# Sizewell C

## Detailed review of the SZC Co. Public Consultation (11<sup>th</sup> June to 12<sup>th</sup> July 2021)

AL_FORDLEY ROAD CH 0.0m TO 148.7m
 SCALE: H 1:1000, V 1:200. DATUM: 5.0

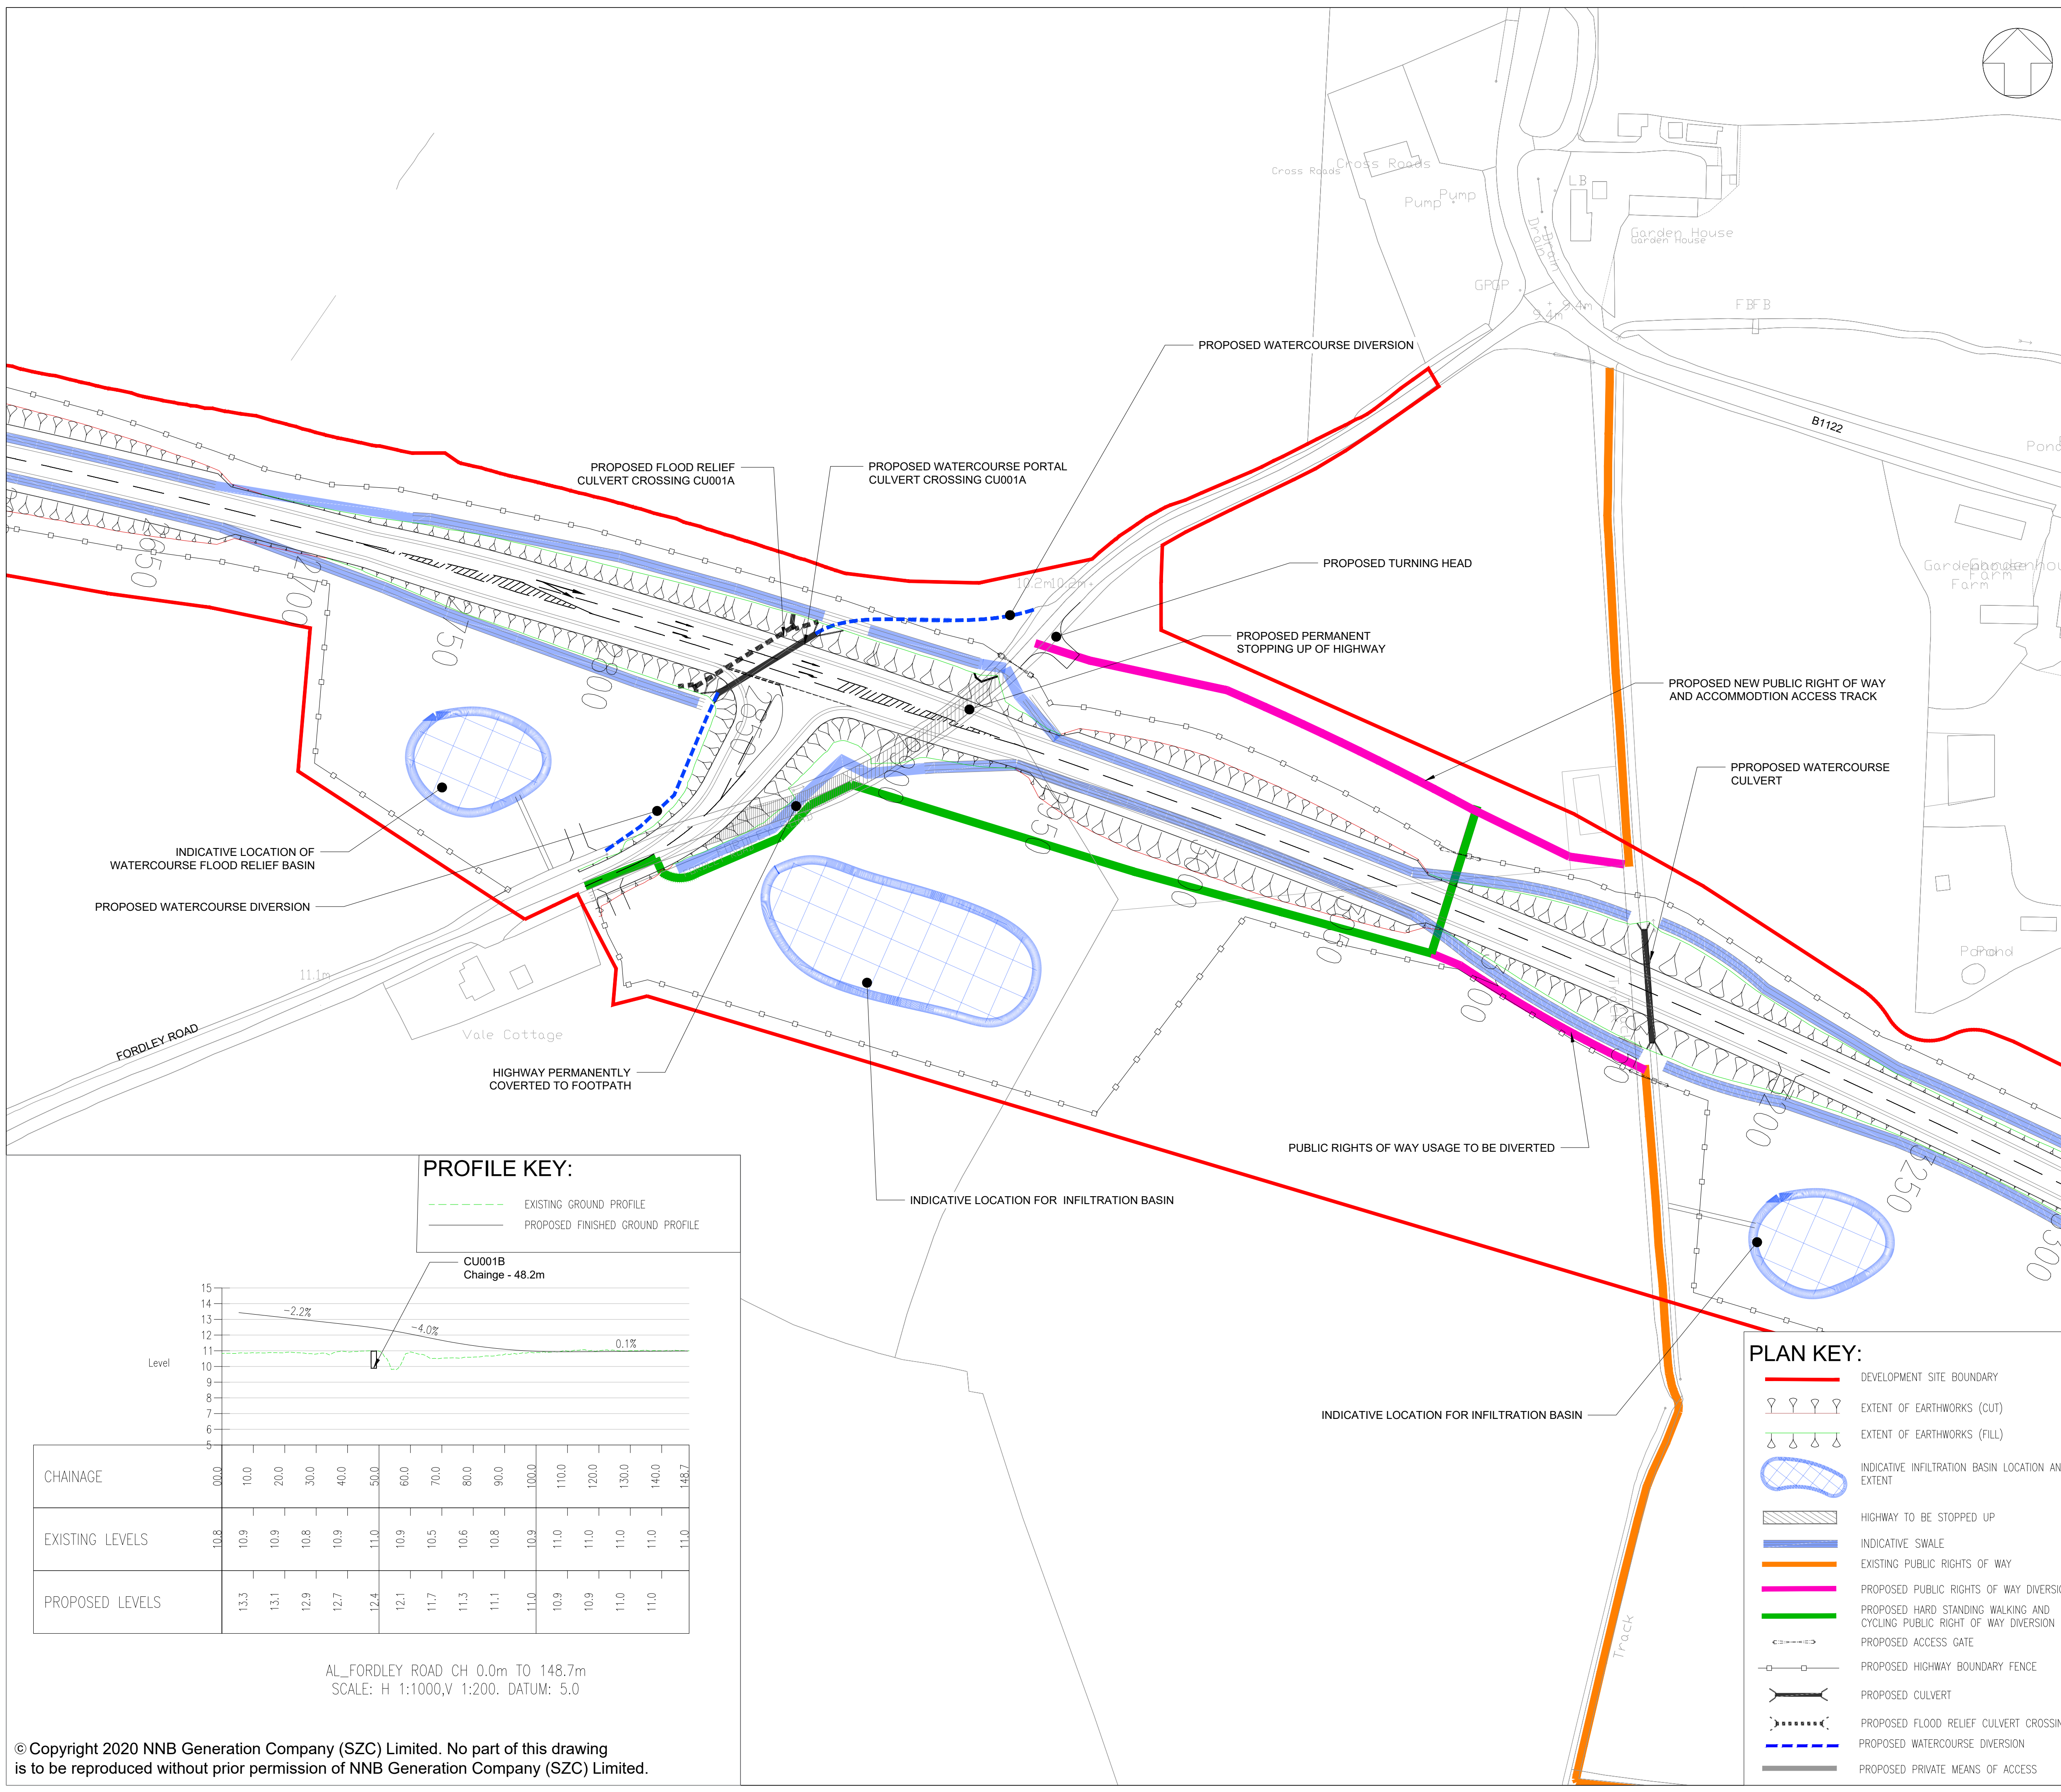
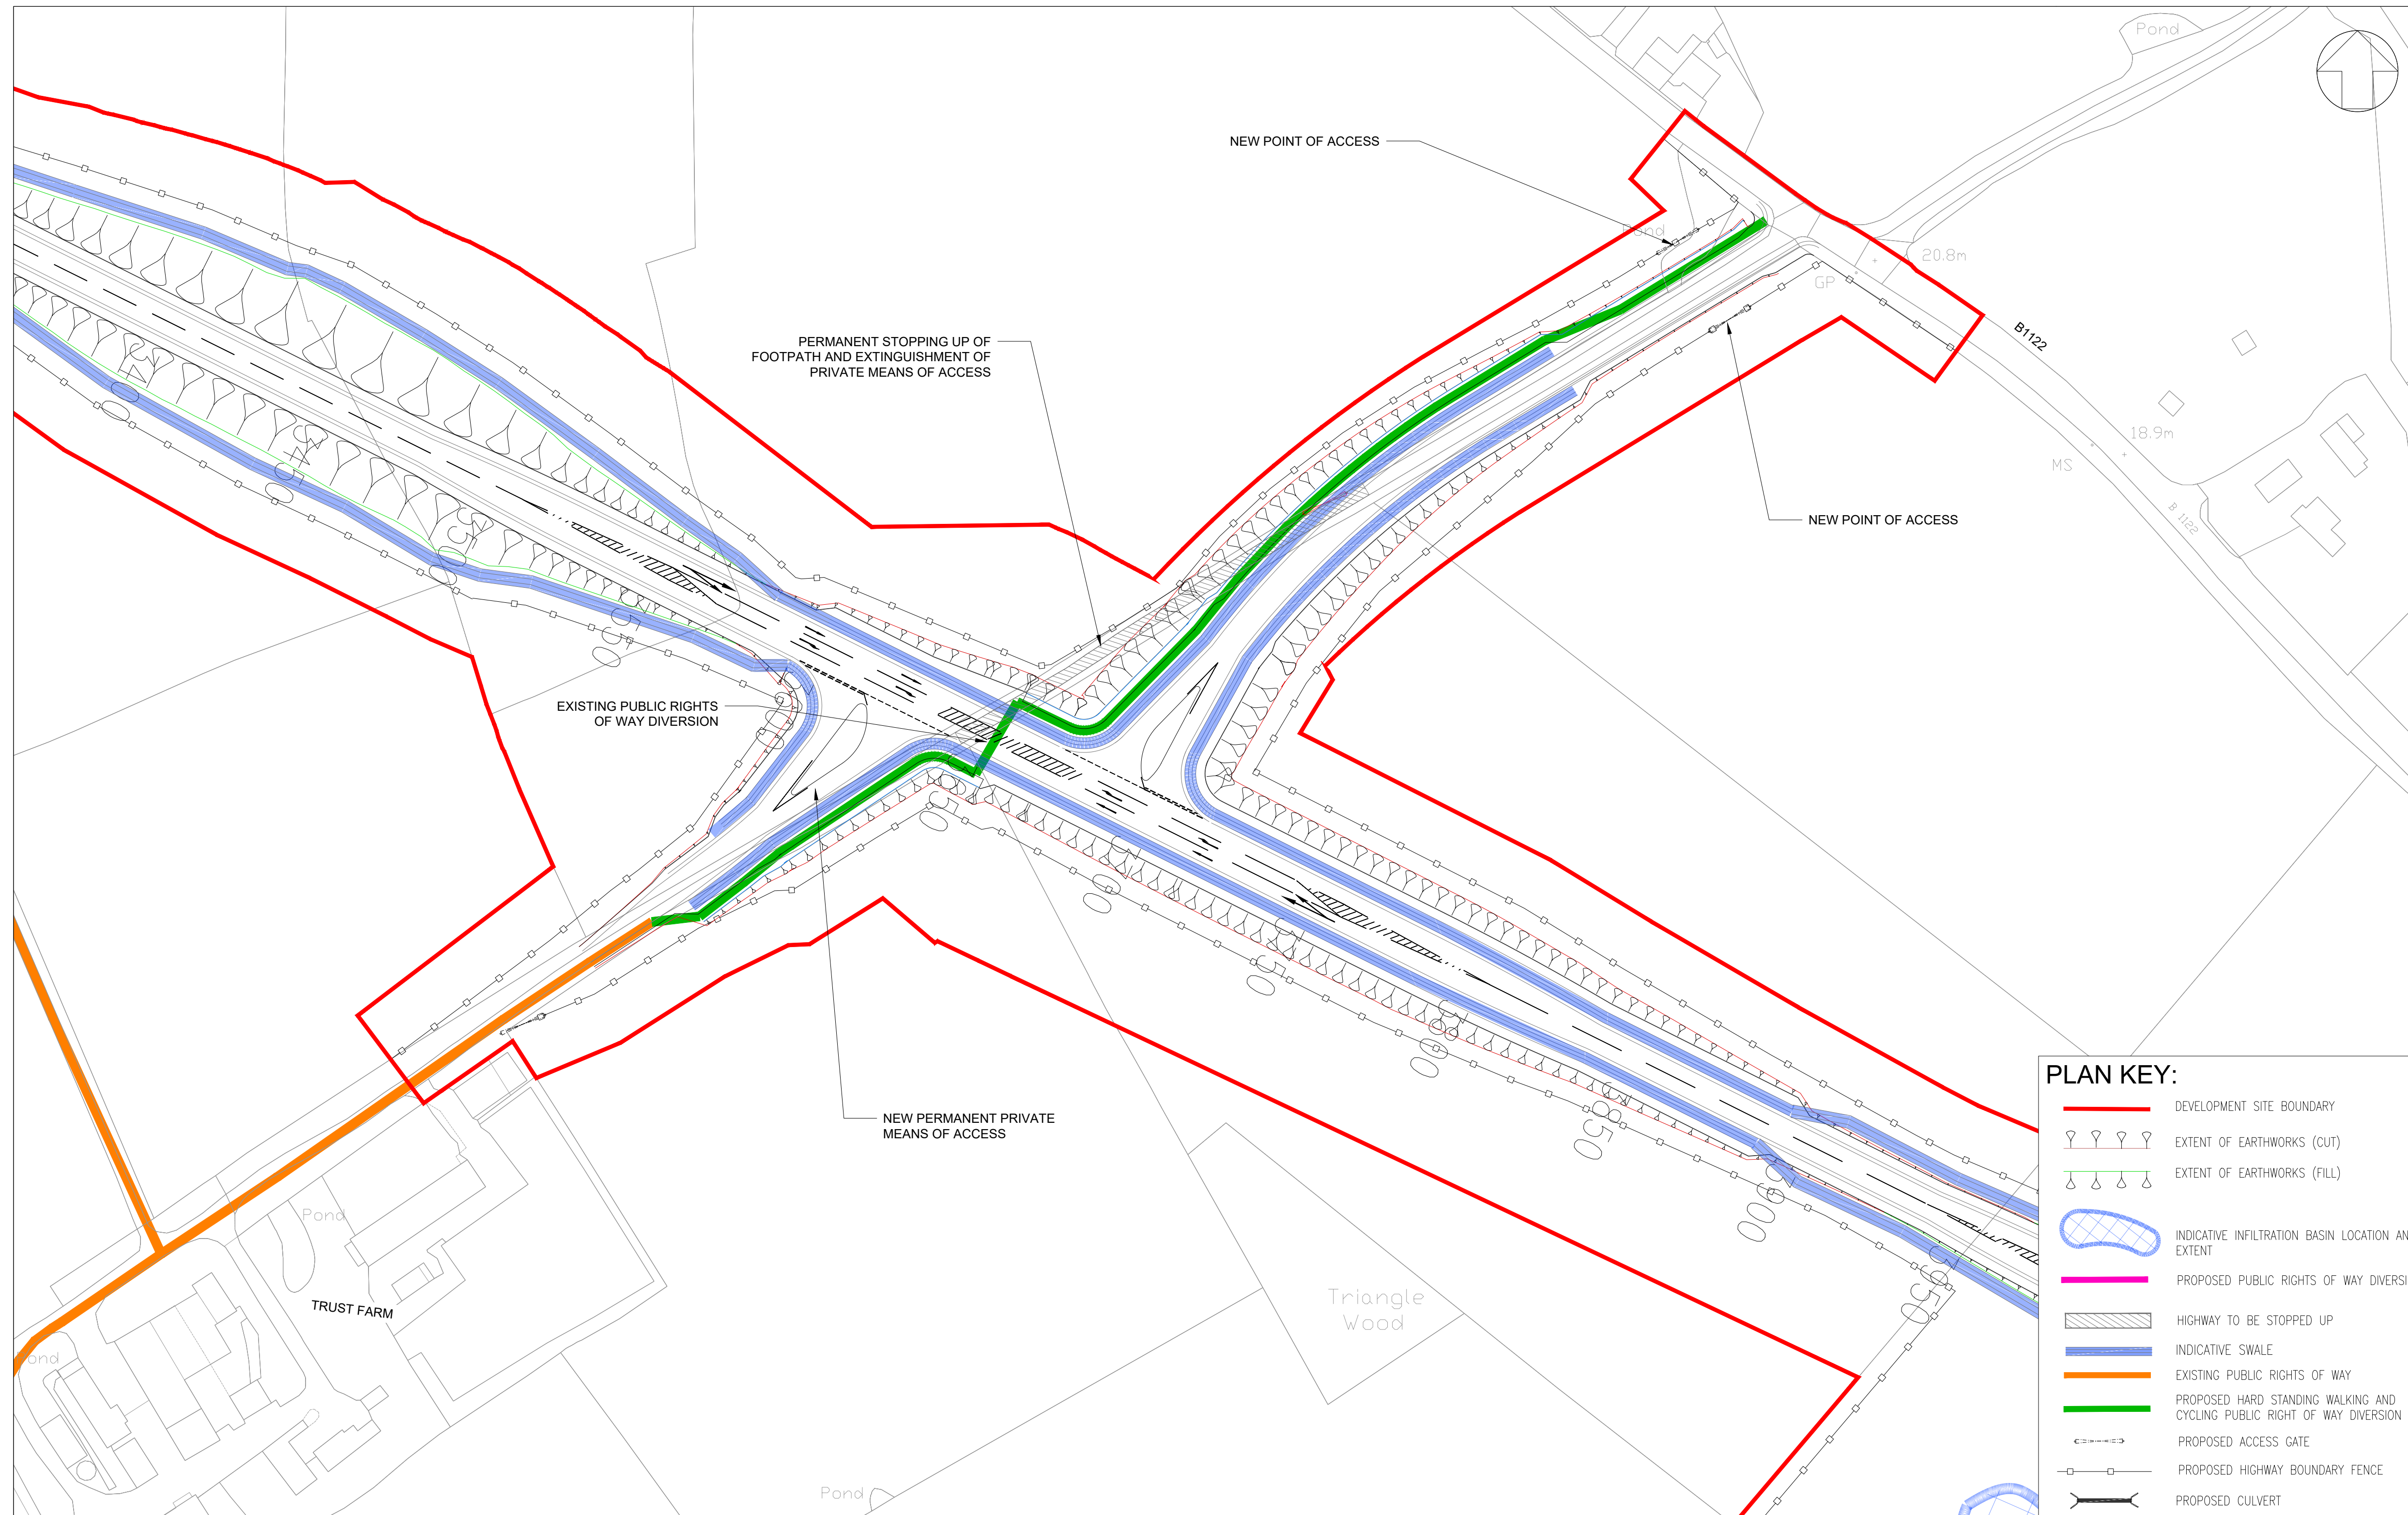
Q According to the consultation document Fordley Road South will still be freely accessible from the SLR thus enabling a “rat run” to form through it and through our Parish. Unfettered access is not acceptable to our Parish and we are consulting with residents in respect of this issue via the Summer Edition of Community News.
